City of Portland, Maine - Building or Use Permit Application

Permit No: 06-1130	Issue Date: PERMIT ISSUED AUG 18	CBL: 24 C013001
-----------------------	---	--------------------

Proposed Use: Single Family Home- link addition to correct roofing problem between house and barn & porch addition	Proposed Project Description: link addition to correct roofing problem between house and barn & porch addition
--	--

Title:
**PROPOSED
ELEVATIONS**

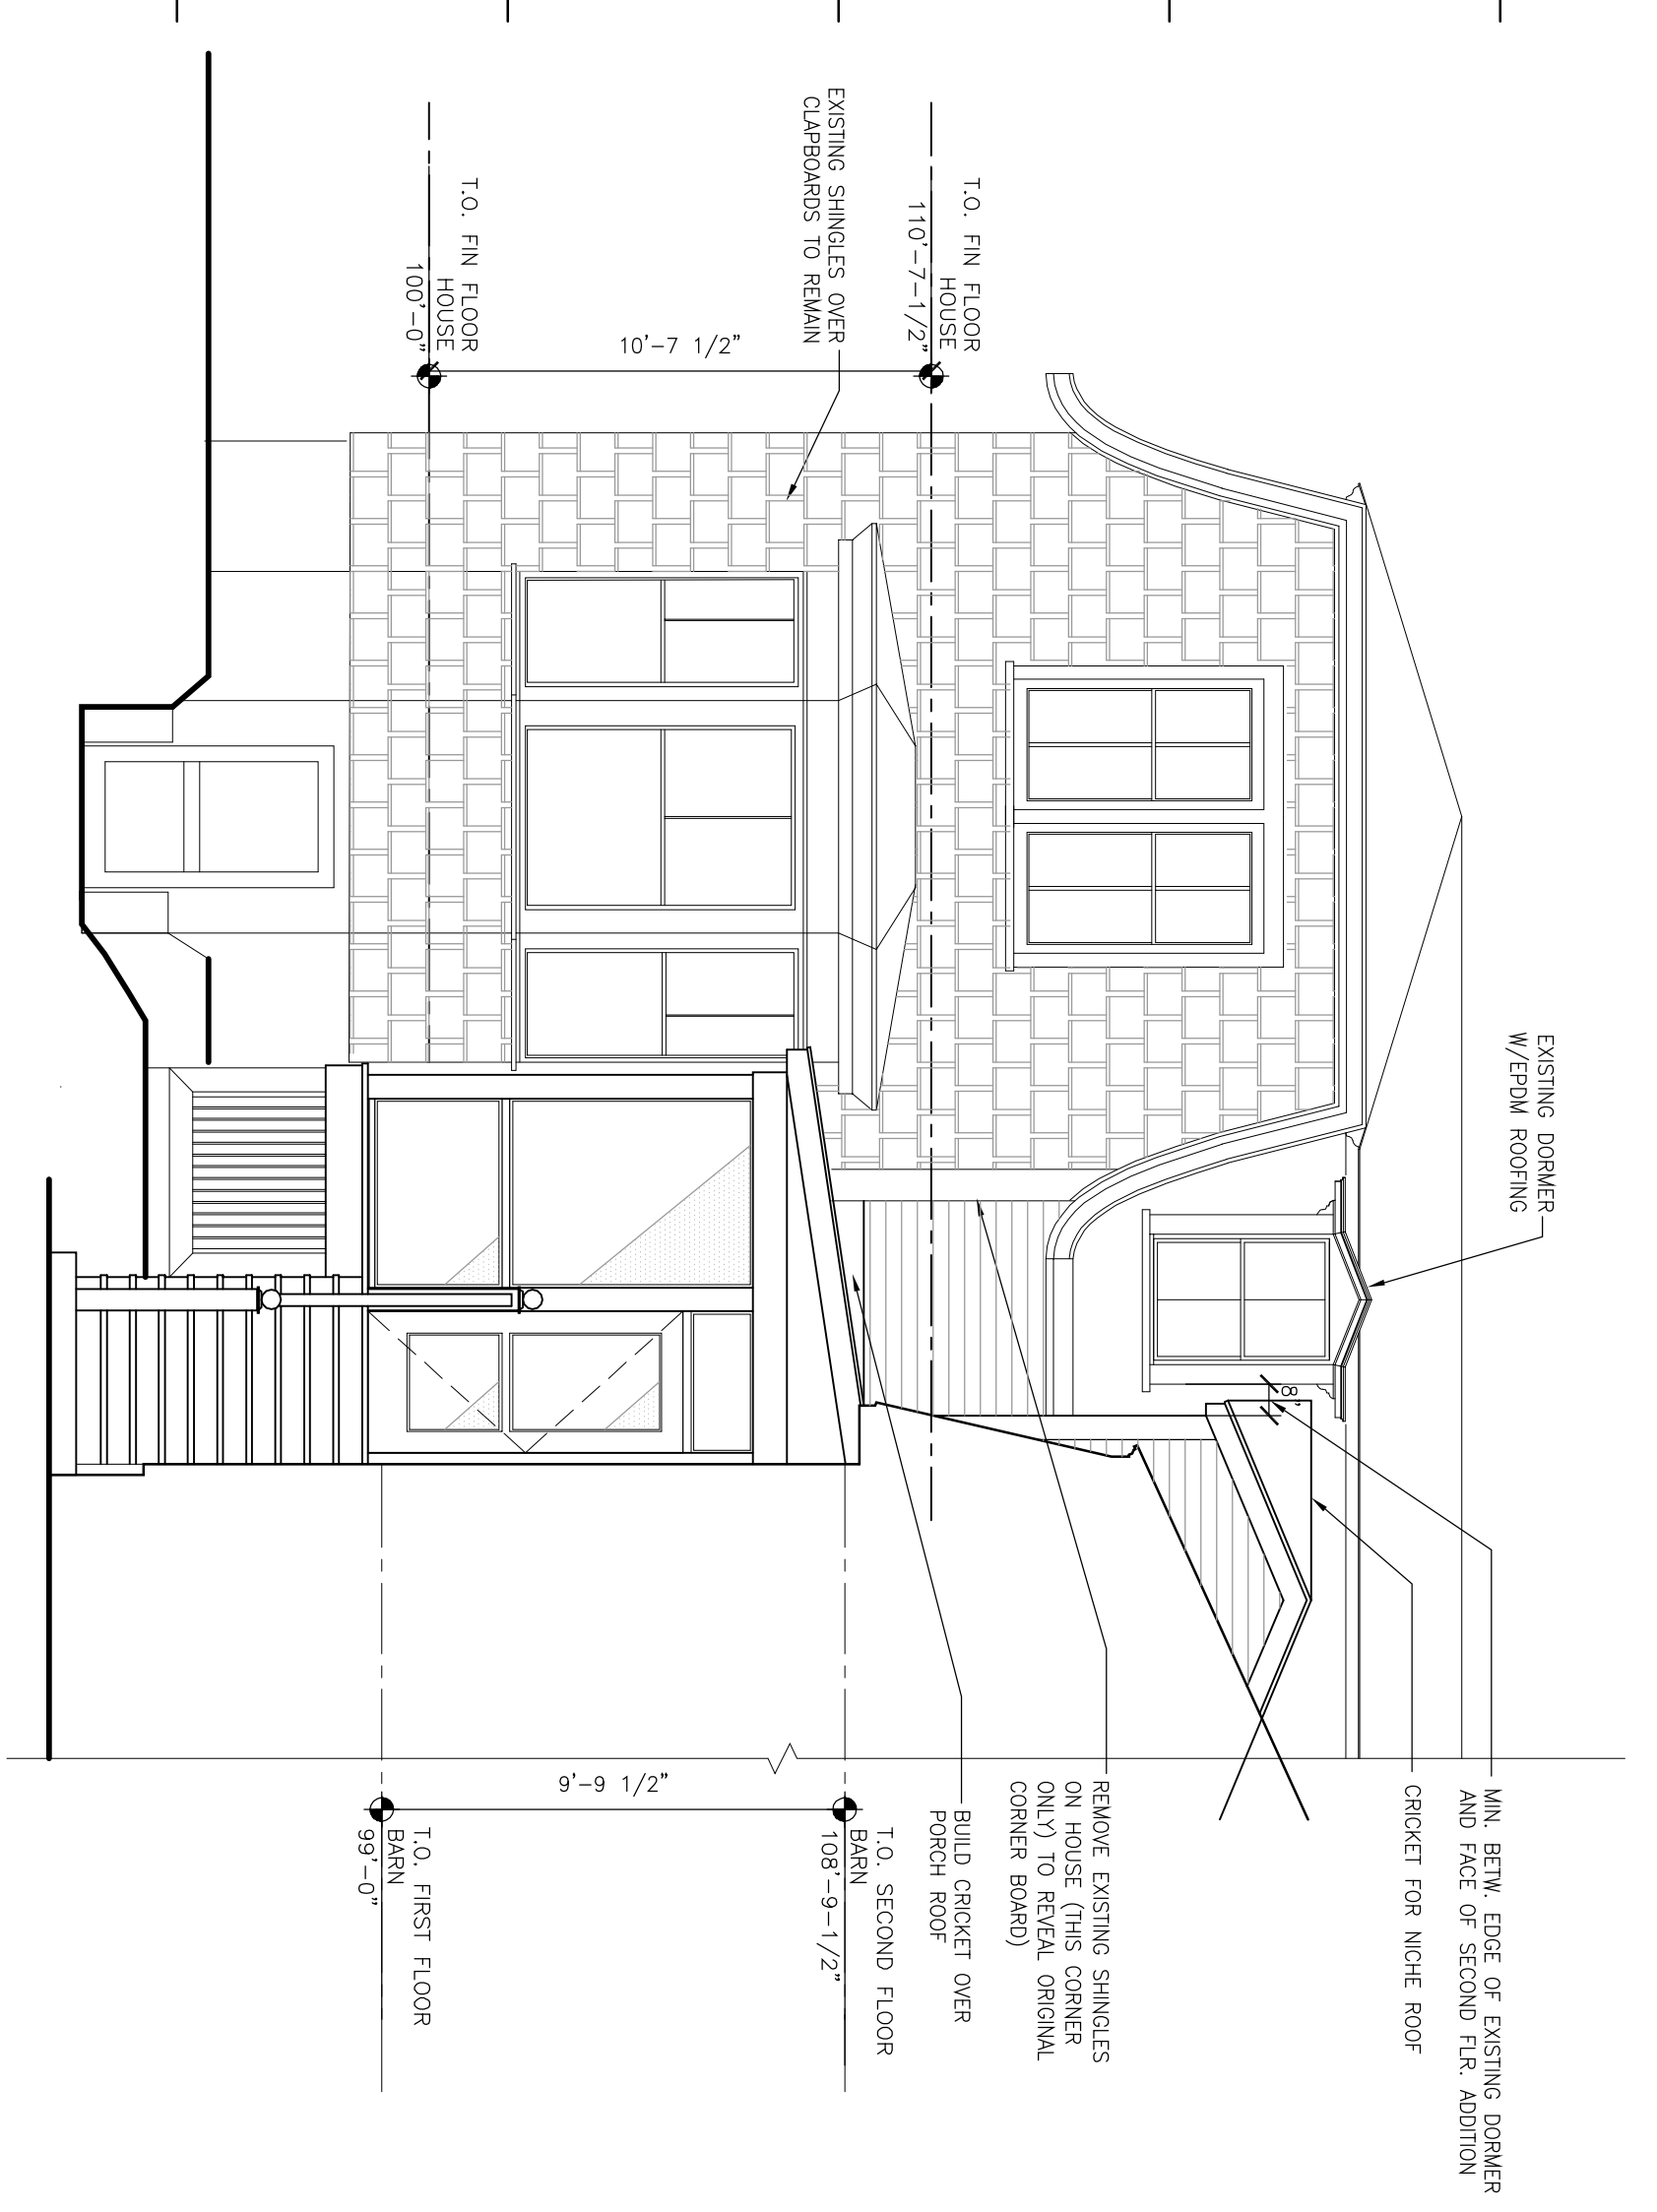
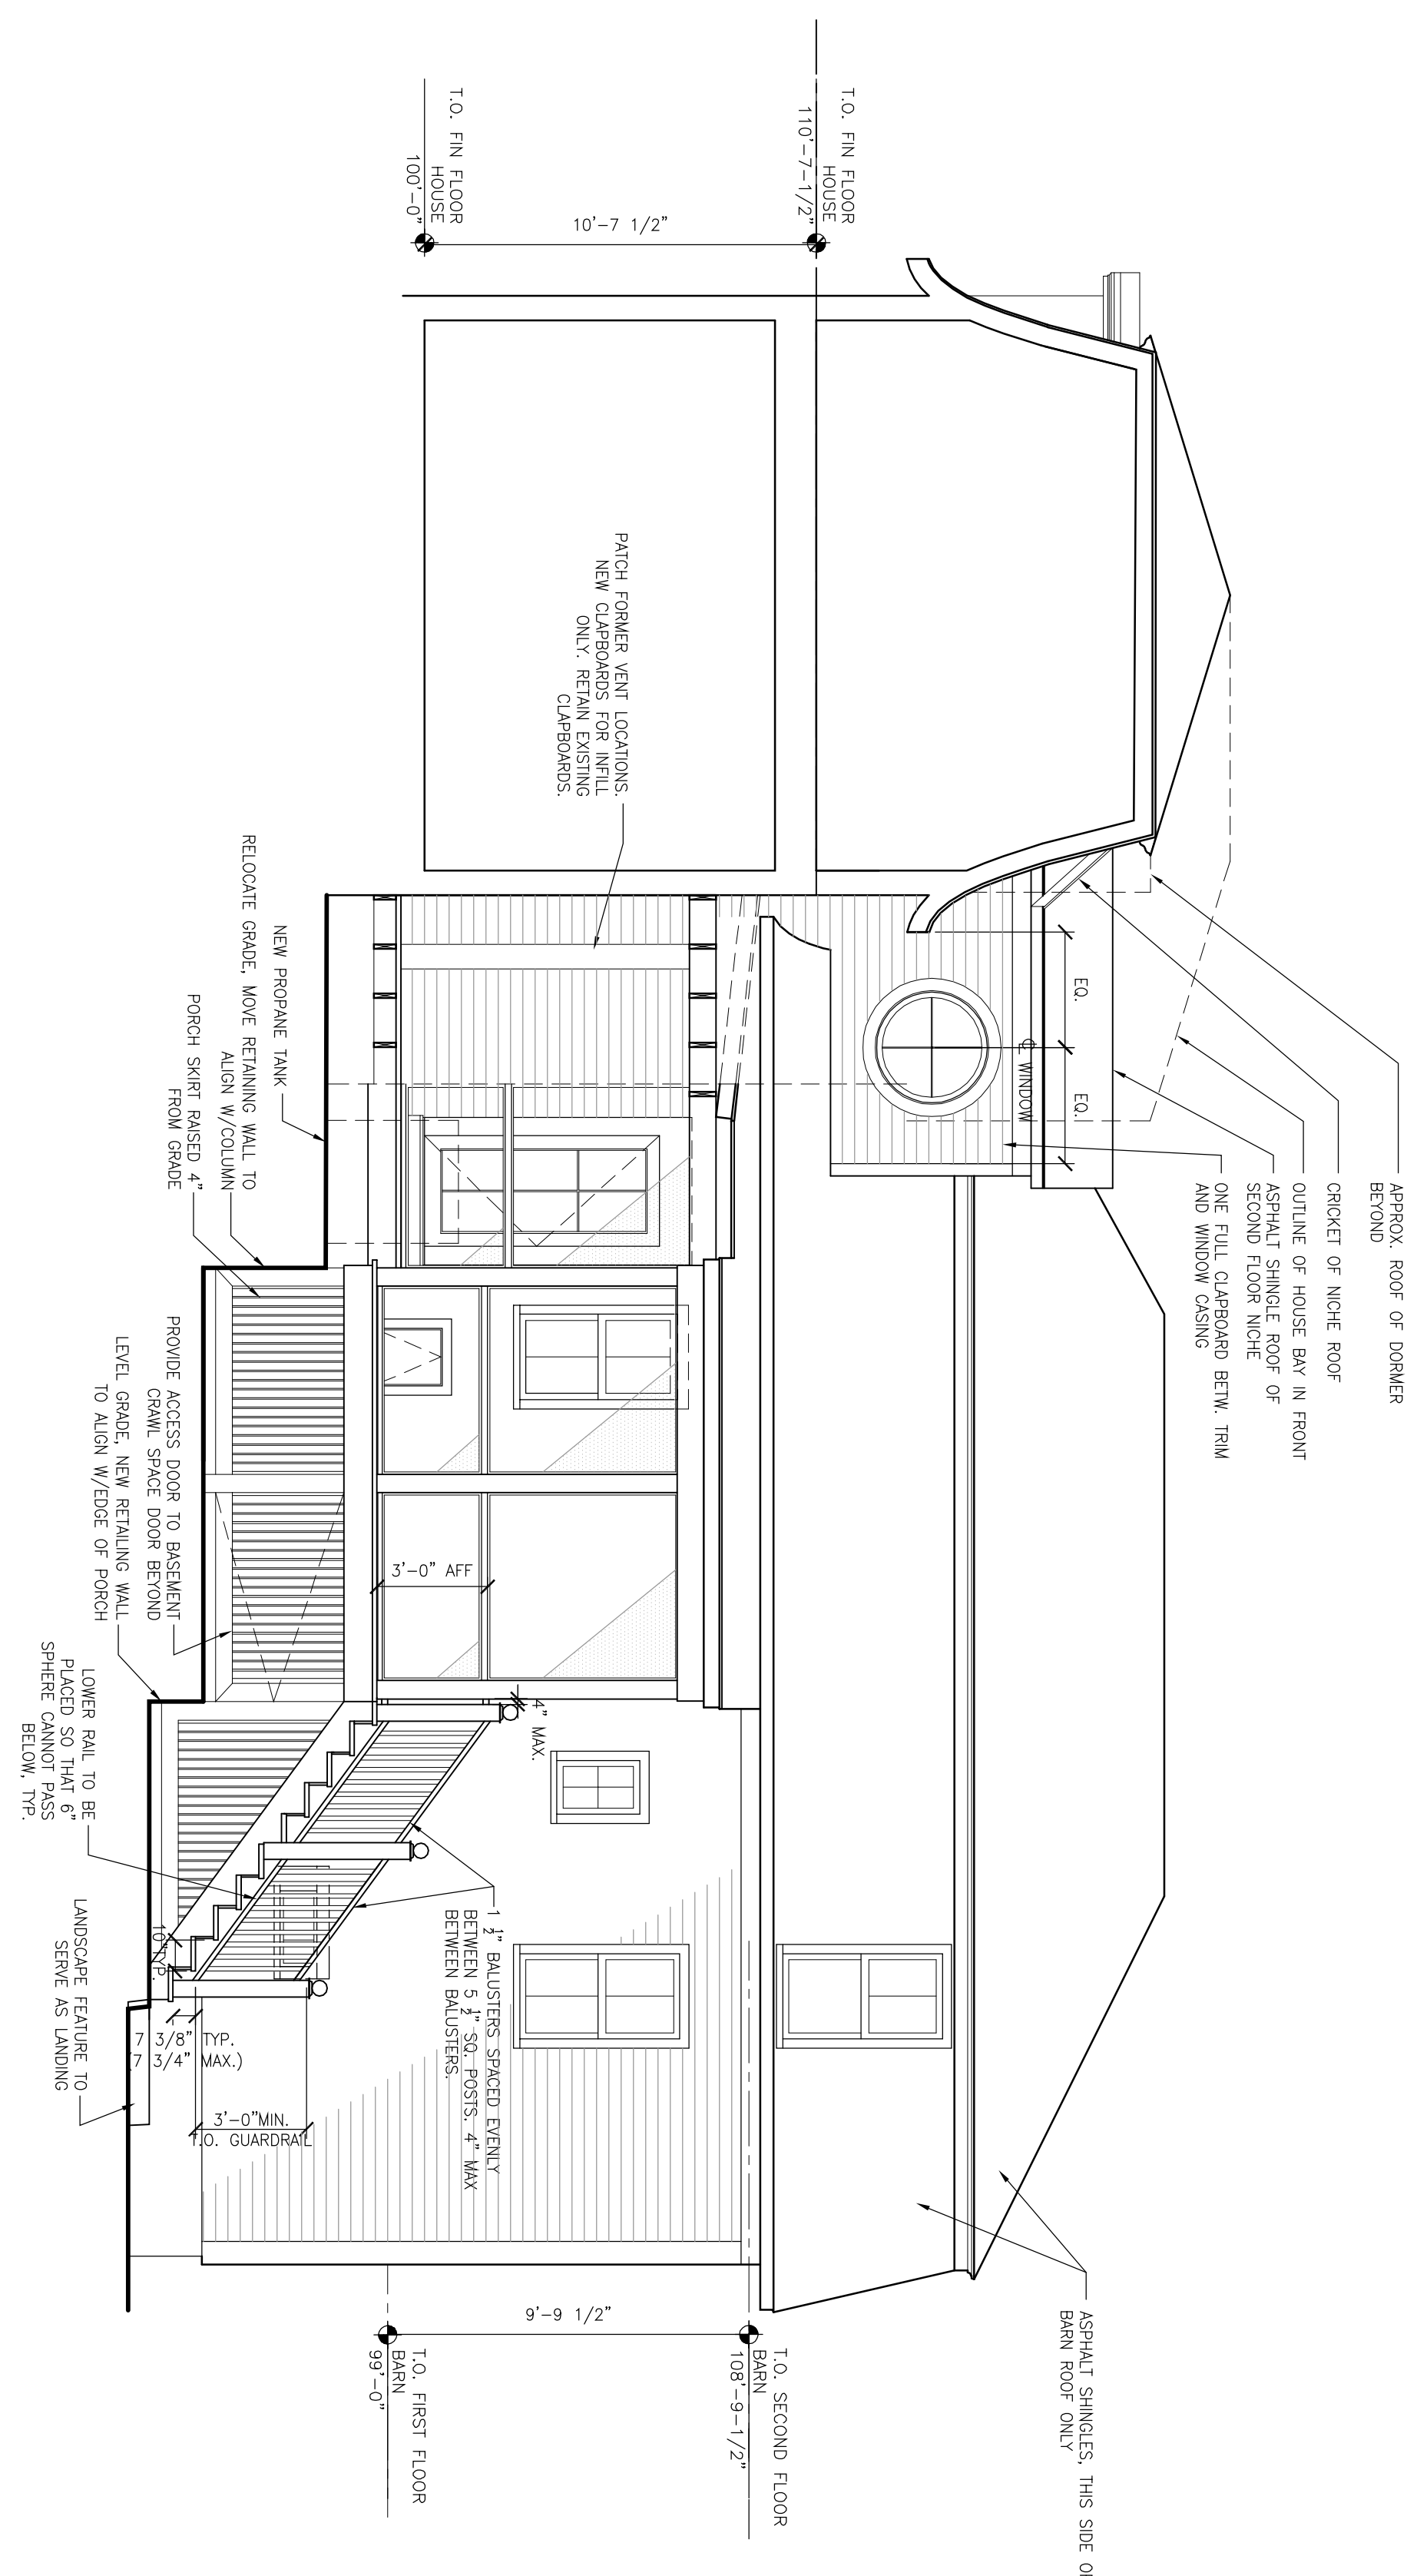
Dept: Building	Status: Approved with Conditions	Reviewer: Residential Plan Review	Approval Date: 08/18/2006
Note:			Ok to Issue: <input checked="" type="checkbox"/>
1) Guards must have openings less than 4 inches, applicant will furnish final guard protection plan for approval for the porch prior to installation of same.
